ExQ4: Issues Tuesday 28 April 2020
Norfolk County Council Responses
Identification reference: 20022890

**Application by Norfolk Boreas Limited for the Norfolk Boreas Offshore Windfarm
The Examining Authority's fourth round of written questions and requests for
information (ExQ4) Issued on 28 April 2020**

Please accept this letter as Norfolk County Councils written submissions in its capacity as local highway authority in response the ExA's fourth round of written questions and requests for information.

CAWSTON HIGH STREET - INTERVENTION SCHEME  
Scale 1:500

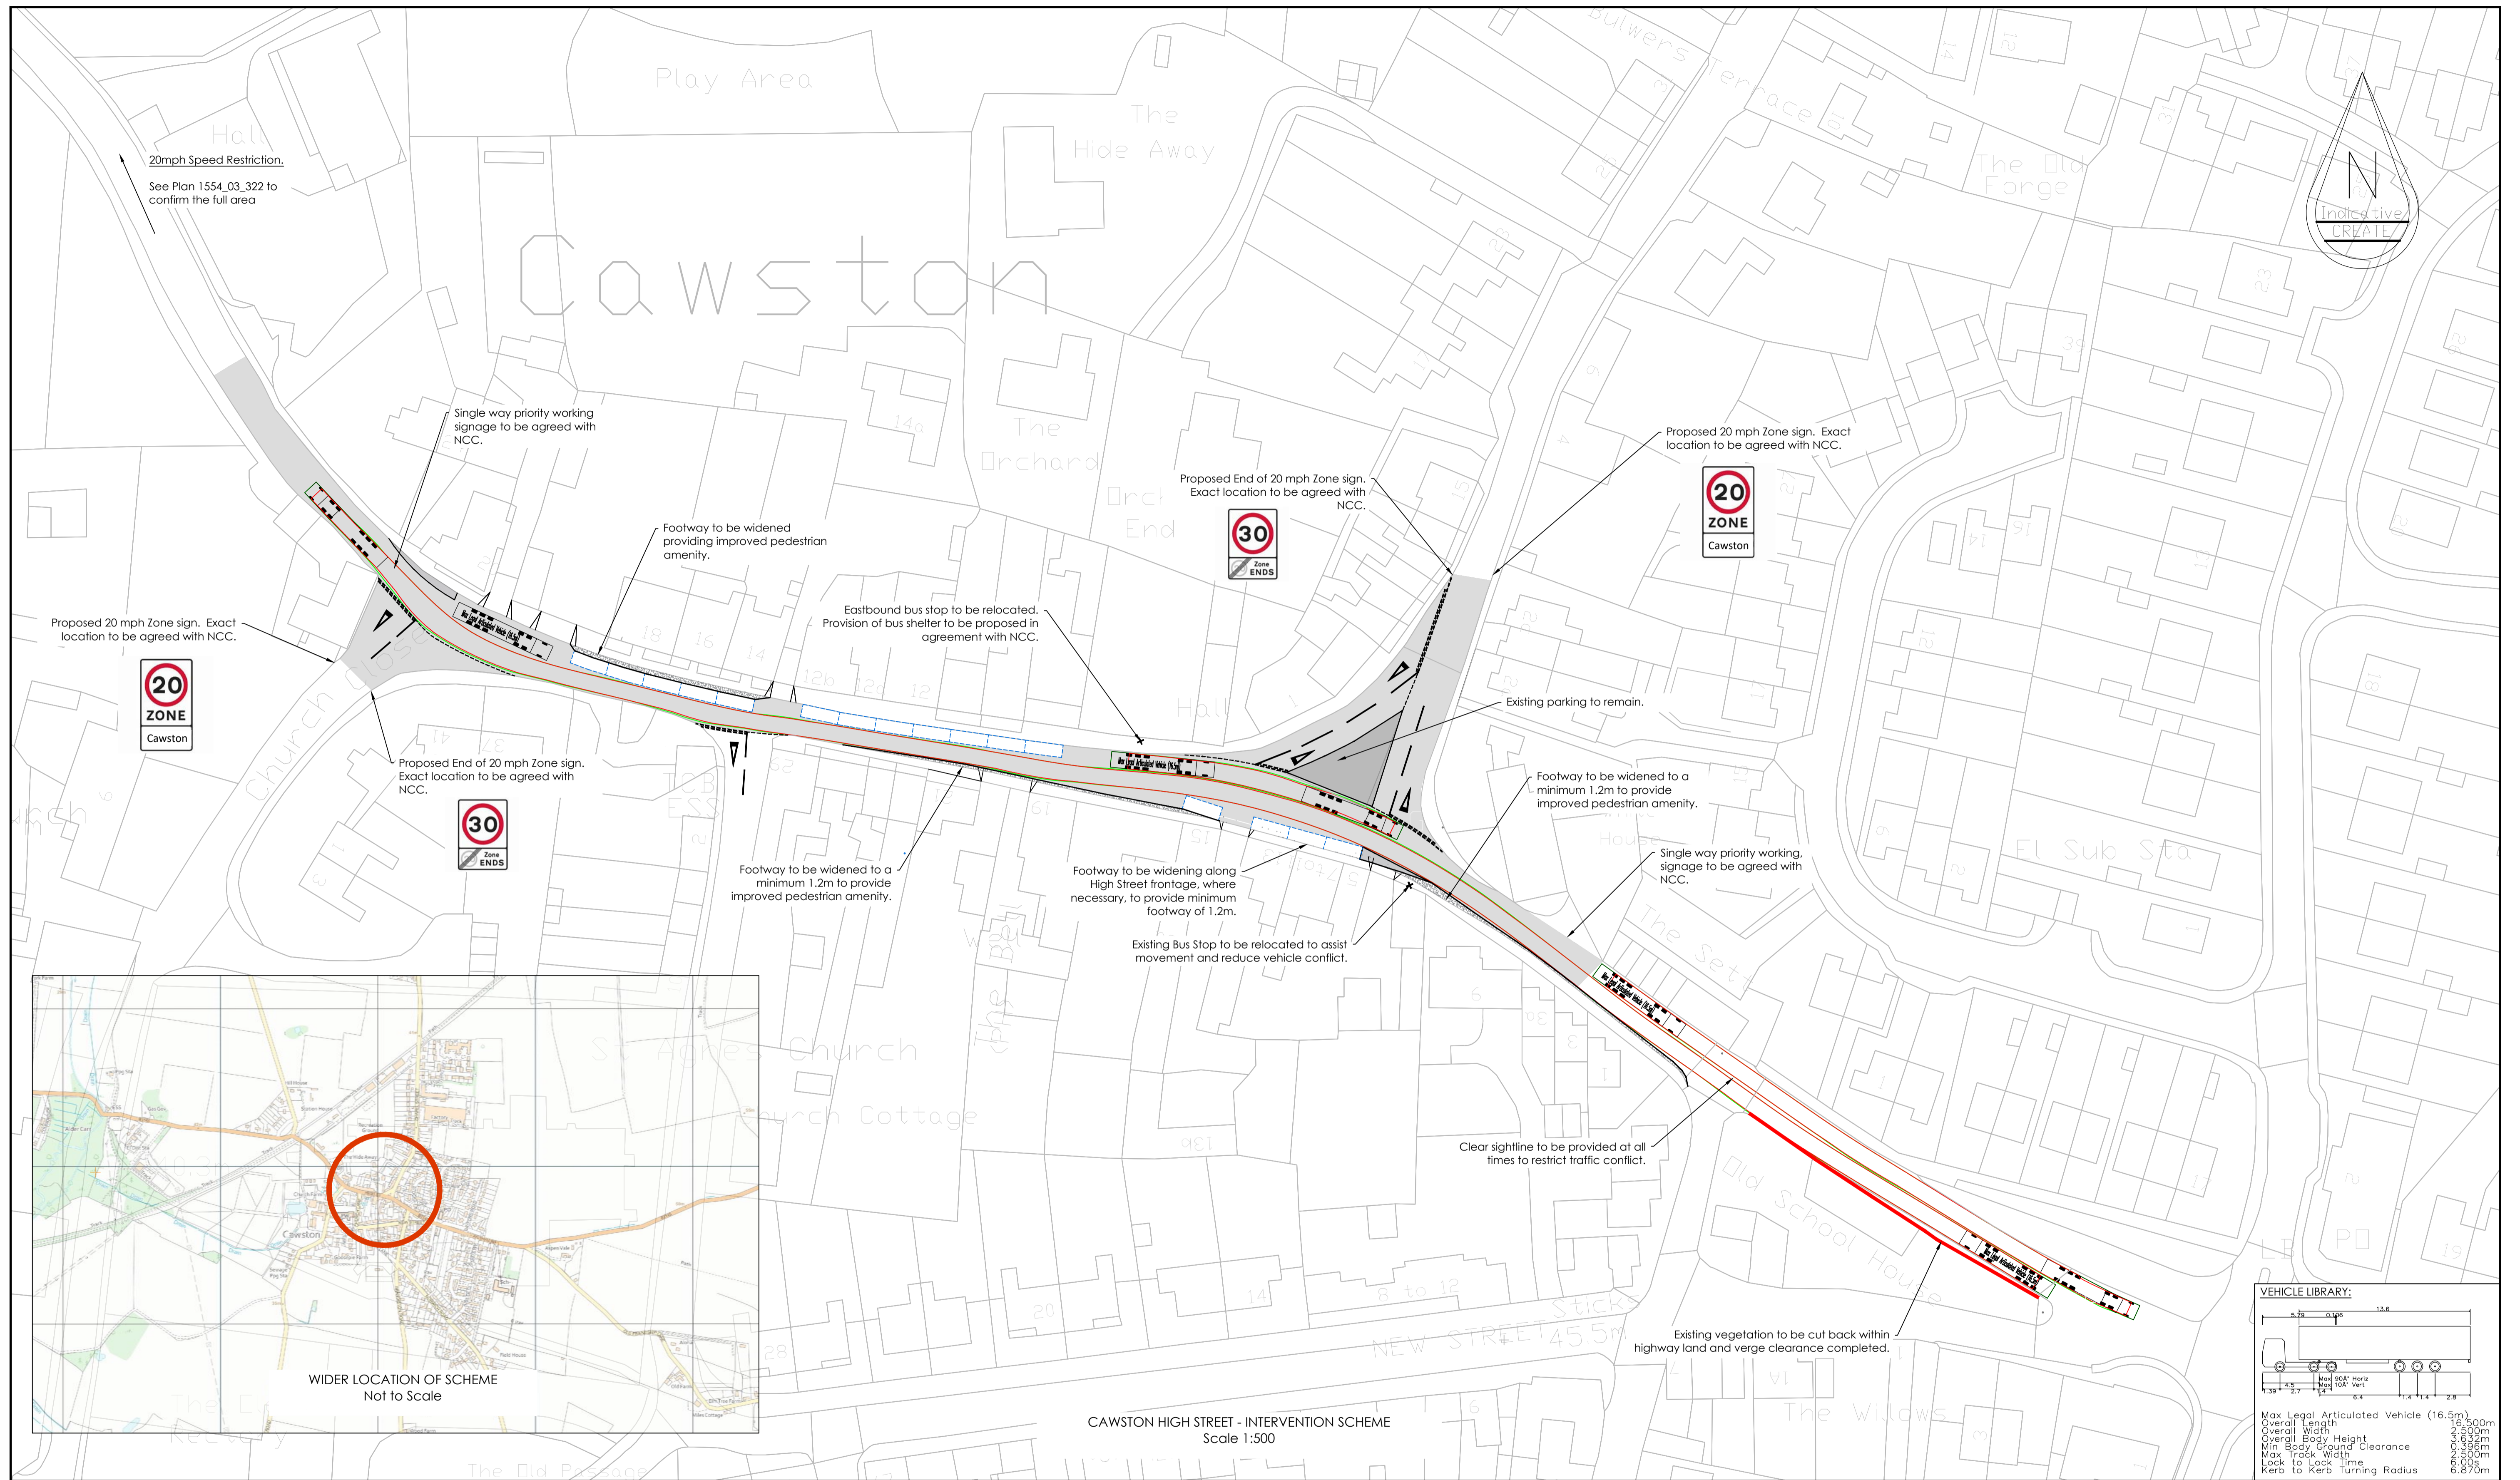
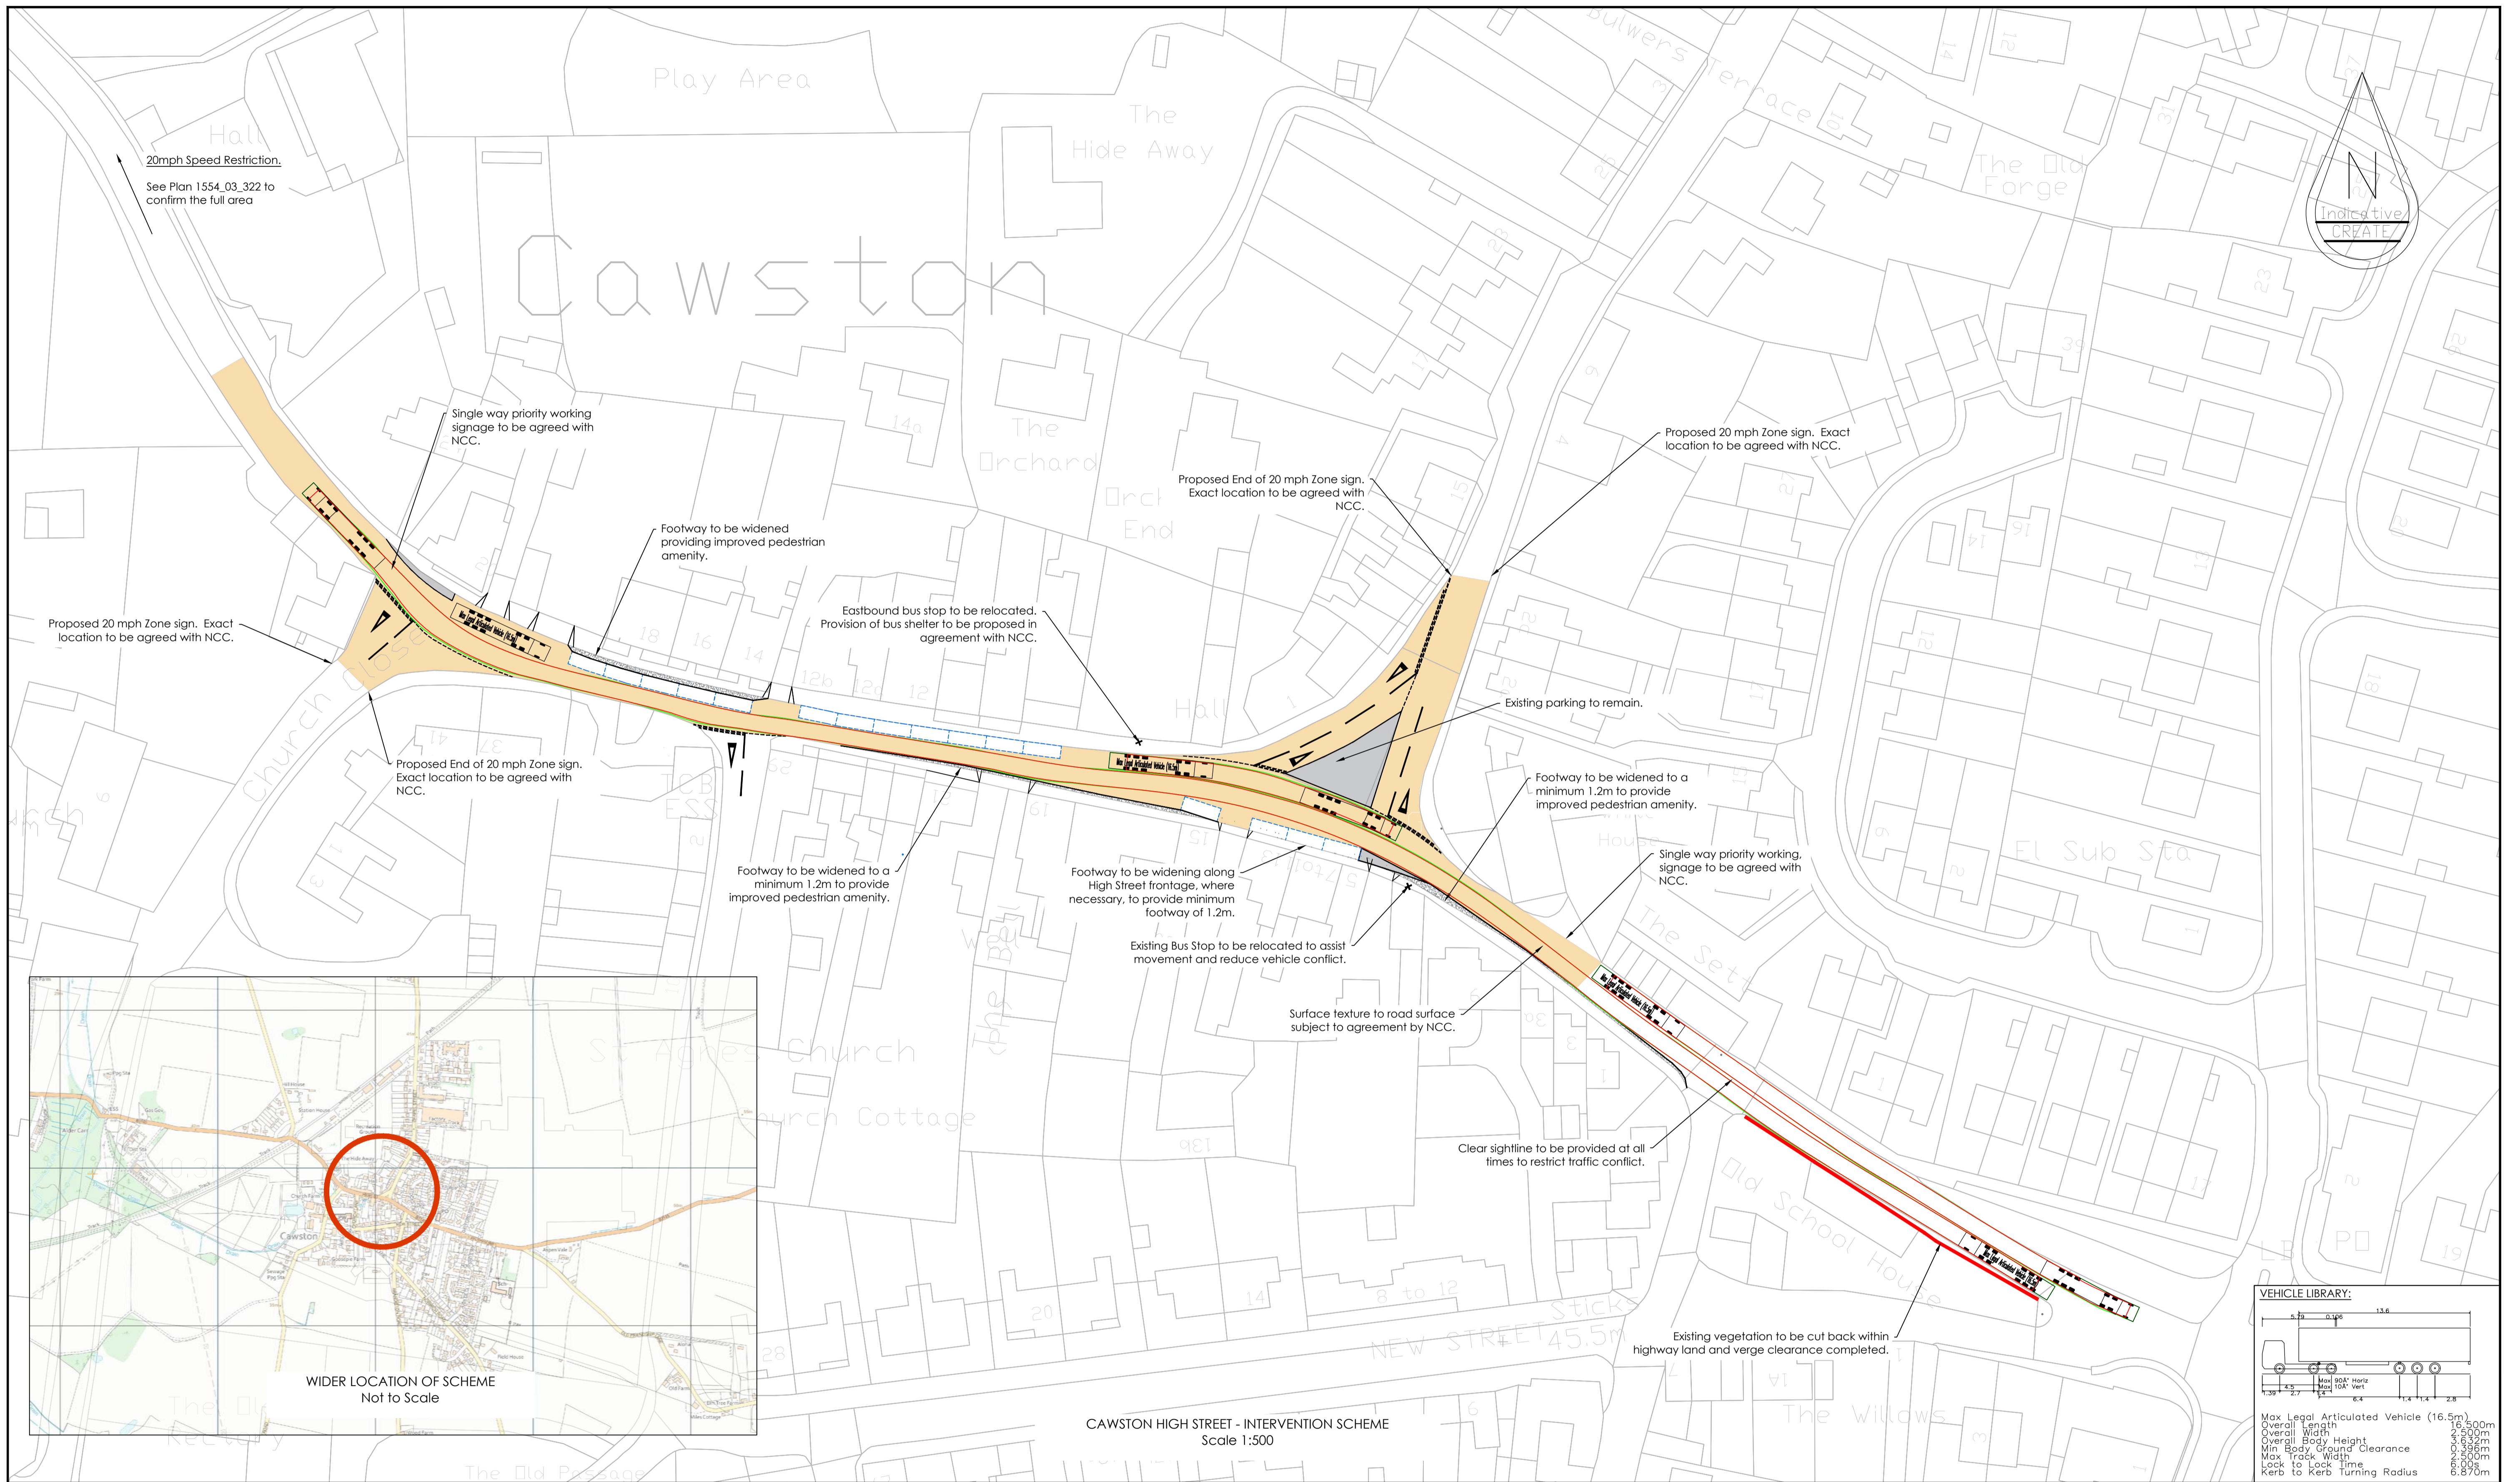
- a) Whilst we have no objection to the Applicants highway intervention scheme (Option 1), nevertheless we have identified a diver compliance issue. This was also identified within the Applicants Road Safety Audit which recommended a review of "...the compliance of drivers following the introduction of the reduced speed limits and introduce further measures if necessary"

If parking occurs outside the designated parking areas; traffic fails to yield at the correct points; or if traffic speeds are much higher than 20mph, the proposed intervention scheme could fail.

- (i) Reducing the volume of traffic passing through Cawston from 239 HGV's per day until a point is reached where there is no longer a compliance issue. However, we fully understand this would lengthen the duration of the project.

- (ii) Introduce a one-way system with the HGV traffic entering the village but exiting via Option 5. We do not support this option as it has several significant safety problems – see our response to Q3.14.1.8 set out below.

In response to our concern, the Applicant has agreed to intensify the monitoring regime to facilitate early warning of issues. Whilst this is welcome and would help identify the exact nature of the problem, it does not in itself provide the solution.

- Rectify any breach of requirements. We fully accept this may be a solution if the problem is limited to a breach of the requirements, but that is not the issue we have identified.
- Introduce warning hazard signs. However, we have already identified the points at which poor compliance is likely to occur and there is no realistic prospect of introducing additional signage at those points.
- Introduce mandatory give-way. This does not form part of the current scheme as it could make matters worse.
- Increased parking enforcement. We agree this may be beneficial and necessary but offers only a partial solution.
- A reduction in the cumulative HGV cap (239 HGV movements) by ensuring Norfolk Boreas and Hornsea3 traffic demand does not overlap. This may go some way to addressing the problem.

NCC would like to see the list of possible solutions expanded with a commitment to reduce the volume of traffic downwards from 239 HGV's per day until a point is reached where (via on site monitoring) there is no longer a compliance issue.

- b) NCC notes there are existing narrow sections of footway throughout Cawston village centre and we are aware of Cawston Parish Council's concerns. The Applicant's response to the RSA, including the specific point in relation to the narrowness of the footways was considered by NCC's development team at its sitting on Monday 9th March 2020. By way of explanation, the team comprised officers from all parts of the Highway Authority including various development management engineers; an area manager for highway maintenance; the growth and infrastructure manager; as well as an internal road safety auditor. The conclusion of the team was that it agreed with the Applicant's response and had no further comment to add.
